Alterations to dwelling under construction. Amendment to approval LY/2/10/ (this application falls within the South Downs National Park Authority)

Thelton House Apartments Crossbush Lane Crossbush Arundel

Thank you for your internet representation made on 6th November 2011 which has been recorded as **an objection** with the comments as follows:

CROSS SECTION THRO PLOT B

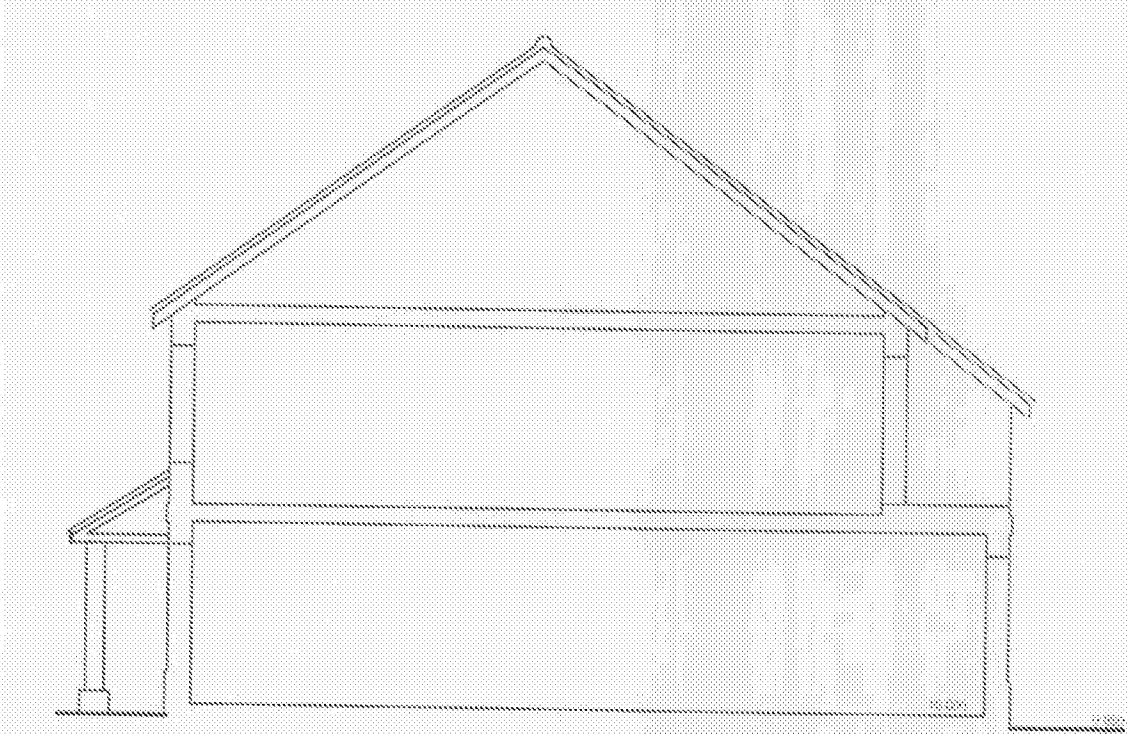
*The introduction of balconies on the West Elevation (WE) and South Elevation (SE) are at odds with whole design of the house; it is not in keeping with the style of the original house (or style of houses in the area); there is no rationale for the balconies - there is sufficient garden space for the enjoyment of outdoor activities. The material of the WE balcony is not specified.* □

*The alteration of the style of windows on the WE is not in keeping with the style of the house - this was an important design statement. The altered windows on the WE are now full length two of which are now opening doors. I have no objection to the extra light created but I do to the idea of the balcony.* □

*There are extra windows in the roof space (gable on the WE and dormer on the SE). This seems as if this is creating a new habitable room - possibly bedroom. This is not part of the original plan and the demand for extra parking facility has not been taken into account.*

*This might involve spilling over to an already narrow road. The windows to on the SE overlook adjacent properties. The level of the dormer windows is higher than any of those in the original house and therefore at odds with the cohesion in "look" of the properties.* □

*In summary: I do not consider these are minor alterations: the introduction of balconies is at odds with this style of house and its adjacent (original Victorian?) property and there is no rationale for them. The style of the windows is at odds with the original house. The introduction of a new habitable room has not been taken into account in assessment of the parking facilities.* □
